Aldington & Mersham Support Group Comments on the Applicants Responses to Relevant Representations (REP1-061)

The Applicant has responded to our **Relevant Representation (RR-003)**. The following document details our comments to this response in the order in which they were responded to by the Applicant. The relevant sections from the Applicant's response are shown in italics with our comments below. We have also made comments regarding the Draft **DCO (APP-015)** and the **Funding Statement (REP1-012)**.

Drawing Title:  
**Illustrative Layout Plan  
 Sheet 1 of 5**

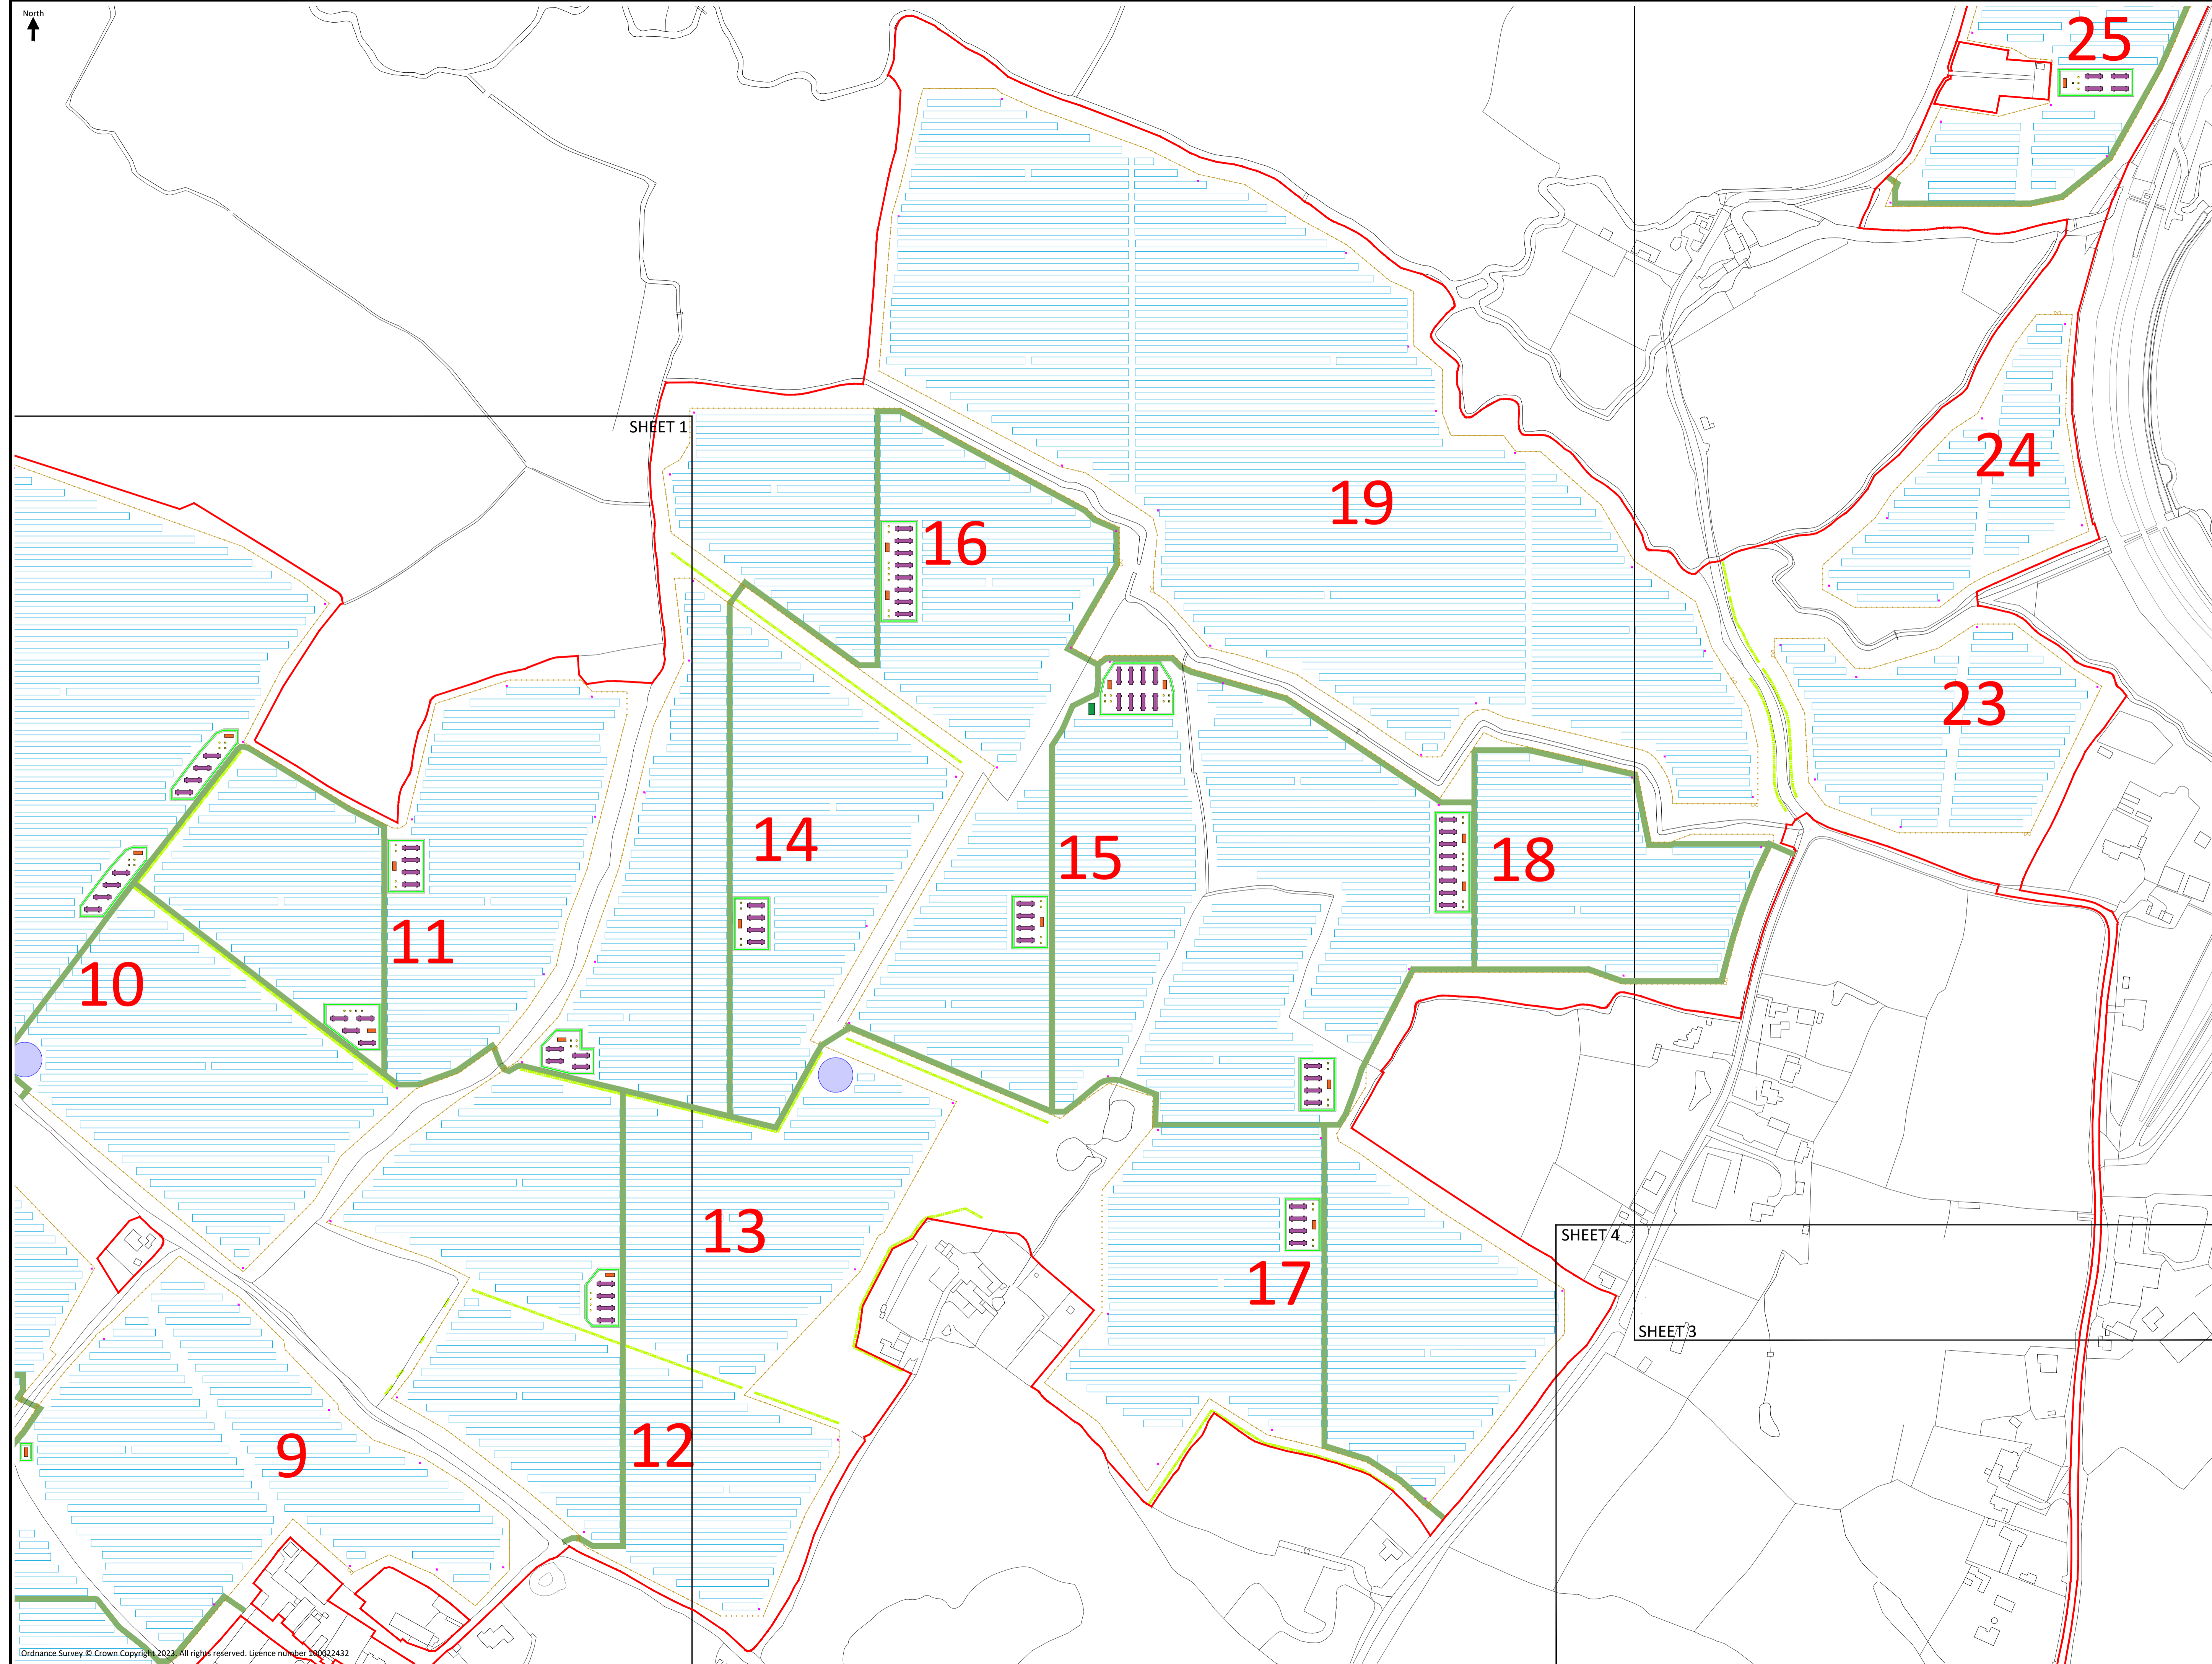
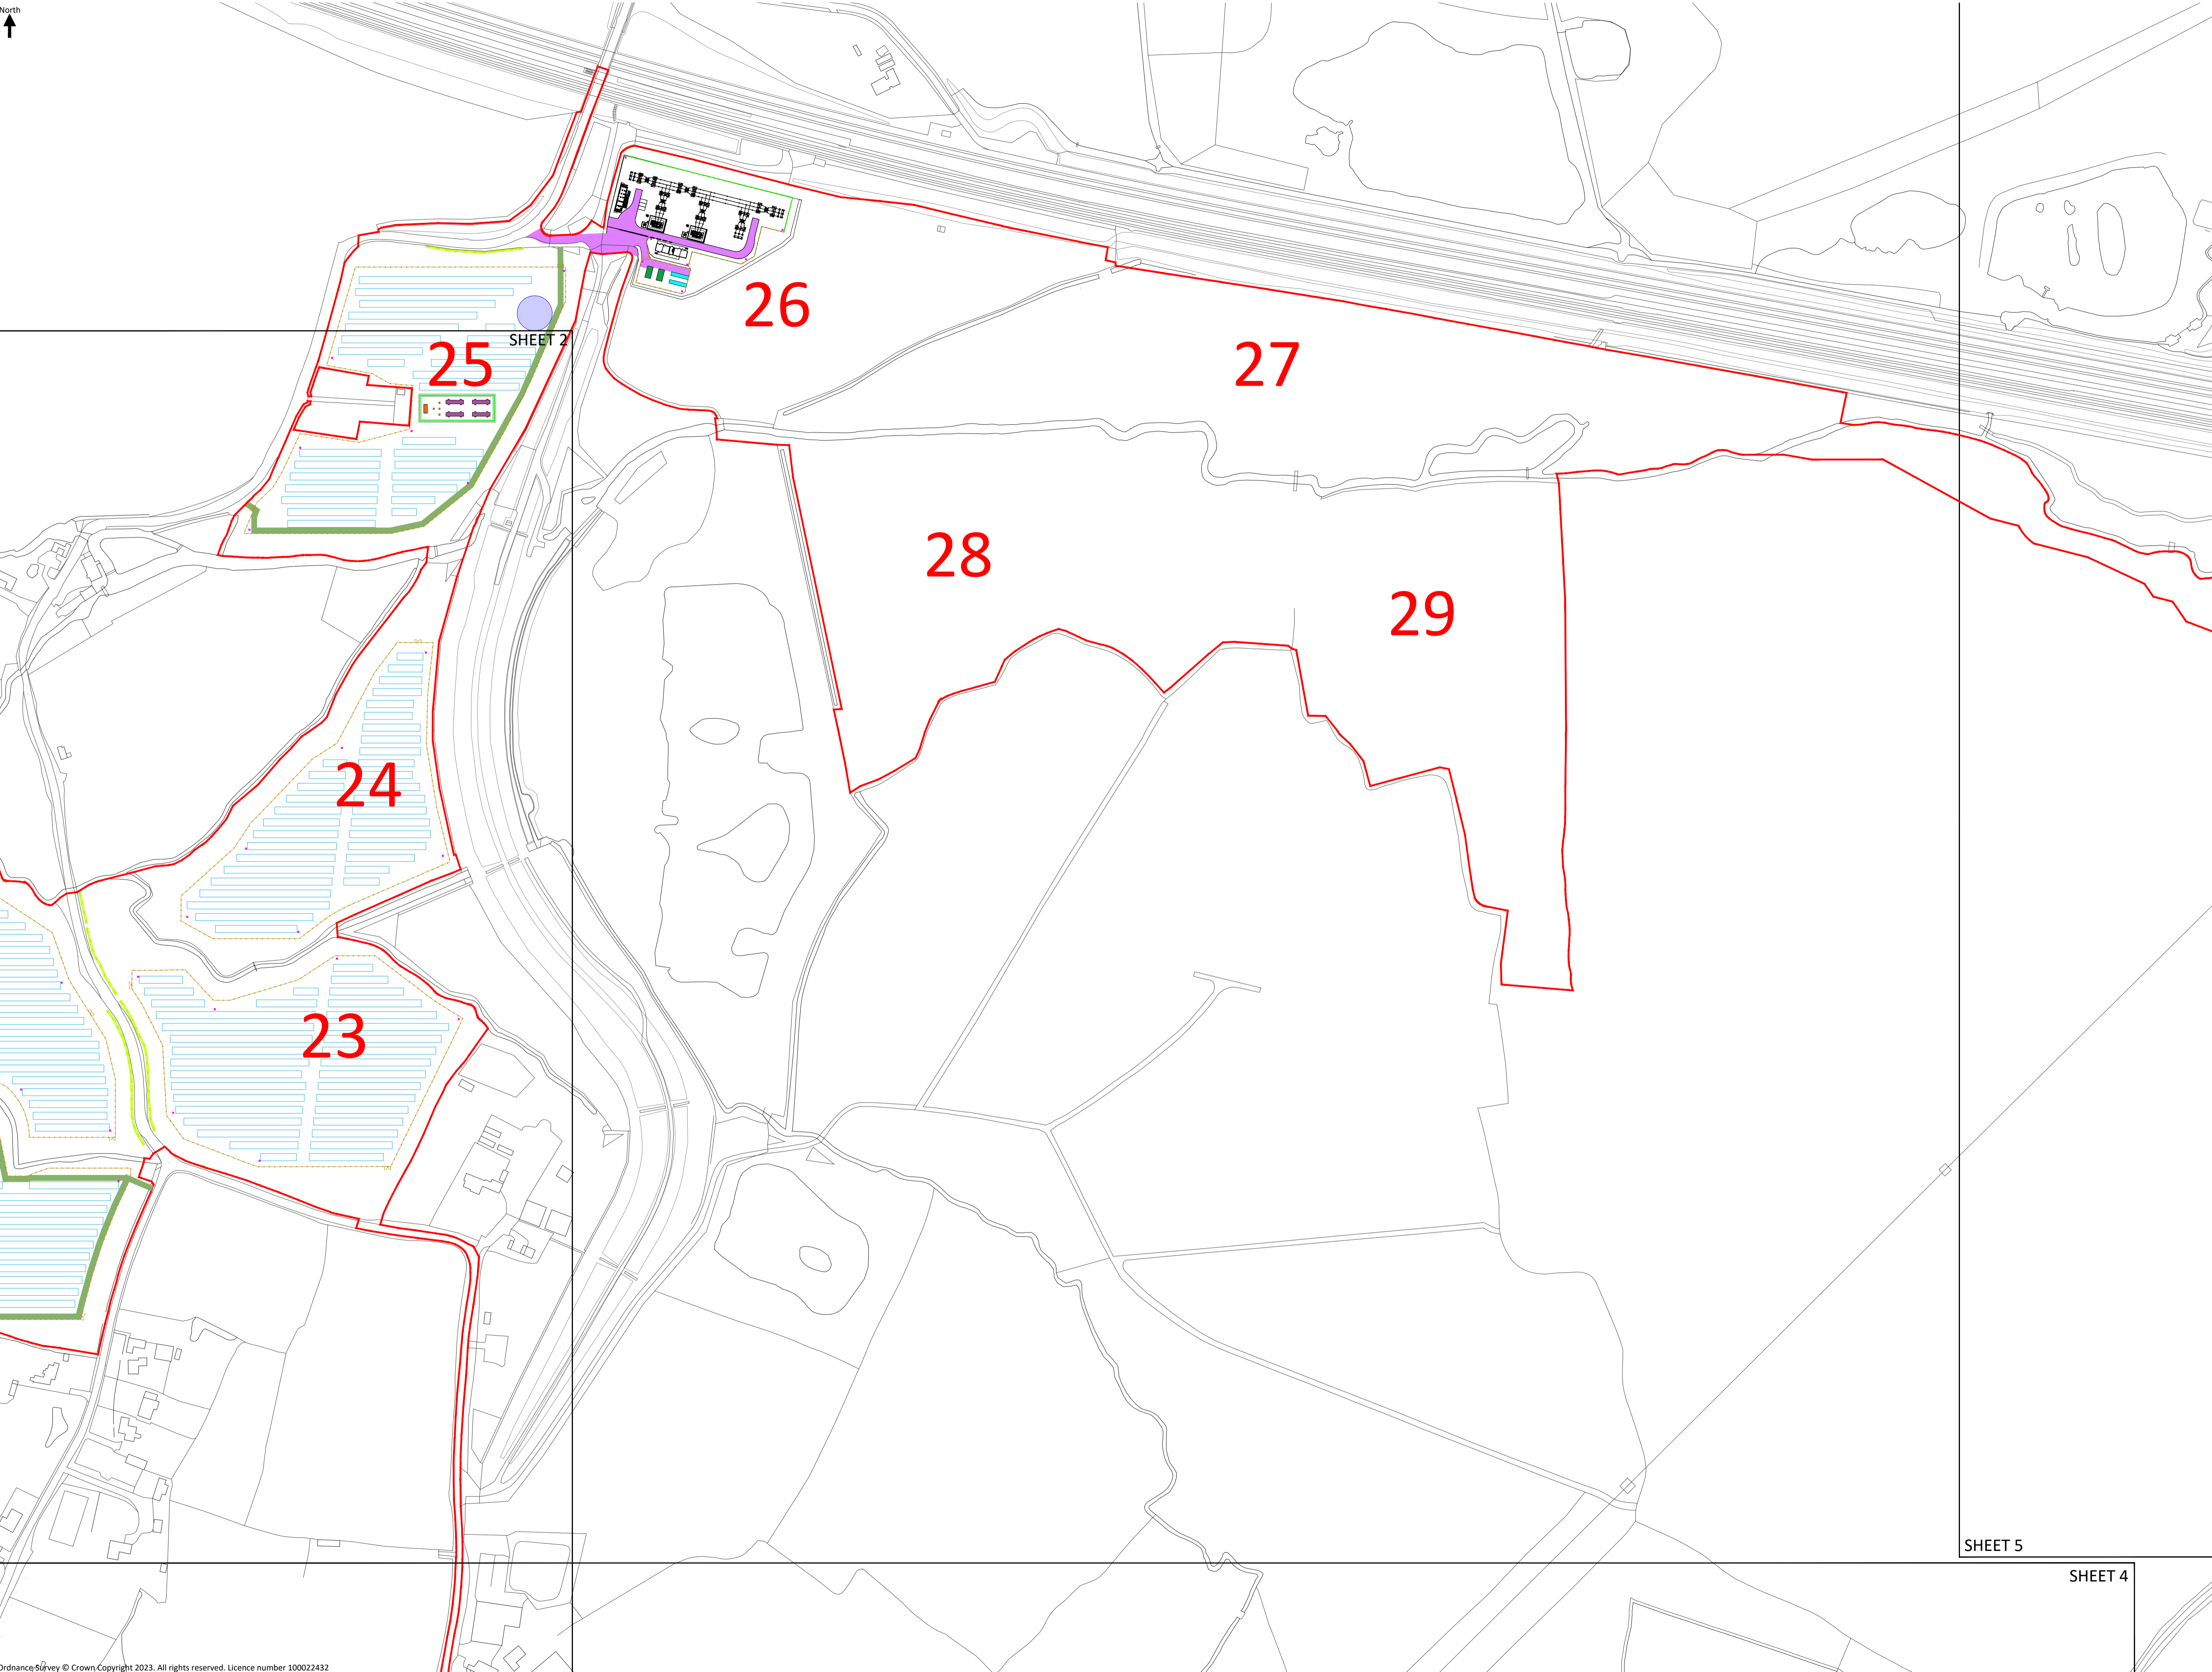
This leaves the so-called “Skylark Plots” to achieve compensation for lost nesting habitat which are the tiny green squares on the plan below which is an extract from the Applicant’s illustrative plan **Doc. Ref 2.7** (note, not for approval).

Possibly the Applicant’s ecologists consider that the recommended 2 No.16 m² Skylark plots/HA recommended for increasing Skylark numbers in autumn sown cereals (as shown below) is equally applicable when located in the middle of the metal and glass of a solar array.

If so, where is the evidence that this has worked in the same way to increase Skylark nesting, and what happens if this mitigation proves to be inadequate? Will some of the panels be removed?

Locating these tiny squares in amongst the panels which themselves can be 3.5 m high (very suitable for predator perching) will offer nothing by way of compensation habitat for the loss of the large amount of so-called arable *monoculture* cropland which in recent years has seen increasing numbers of ground nesting birds – particularly Skylark (where the main landowner has in the past erected signs to encourage dog walkers to keep dogs on leads to avoid disturbing nesting Skylark).

Fence Panel Detail - With Two-Way Animal Access Gate  
Scale: 1:50@A3

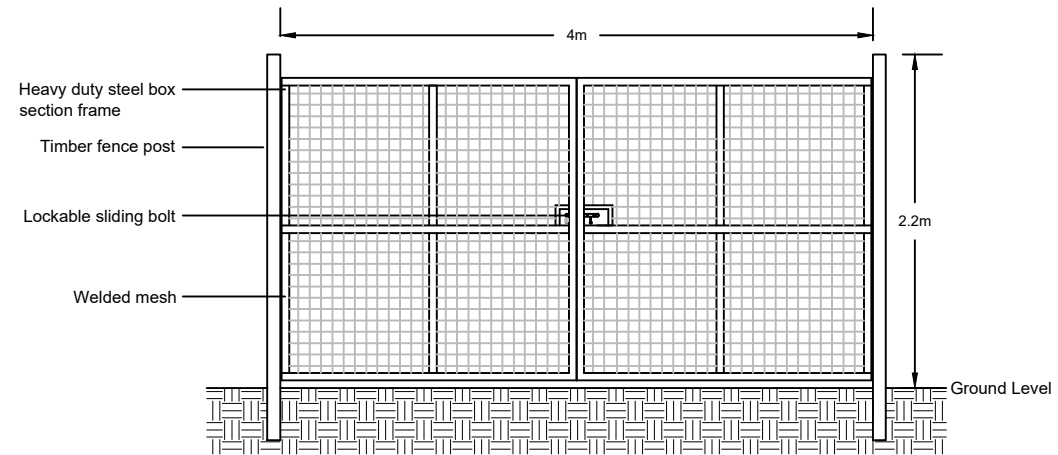
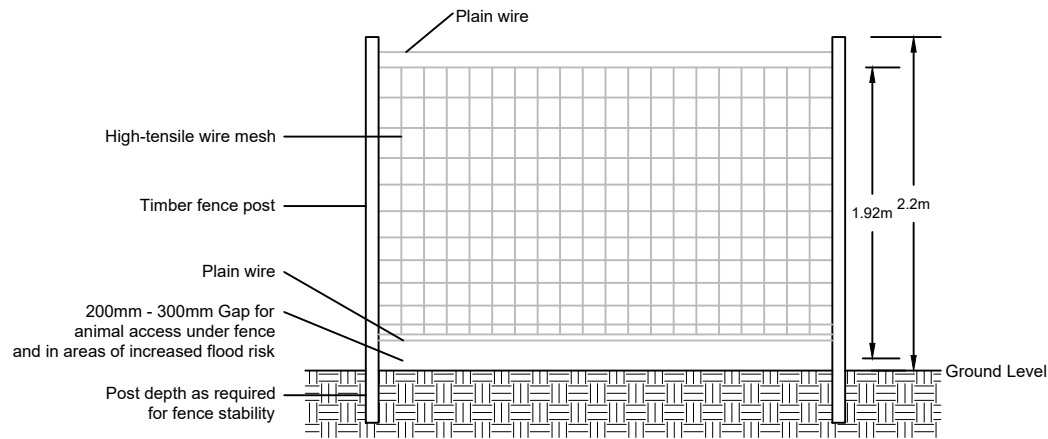
The true position is that mammal movements **will be restricted** because the only means of them accessing existing foraging areas will be through an unspecified number of mammal gates. Why has the Applicant not indicated a minimum number of these gates to be installed?

Why has the Applicant not said, “will include” rather than that it will “look to include”?
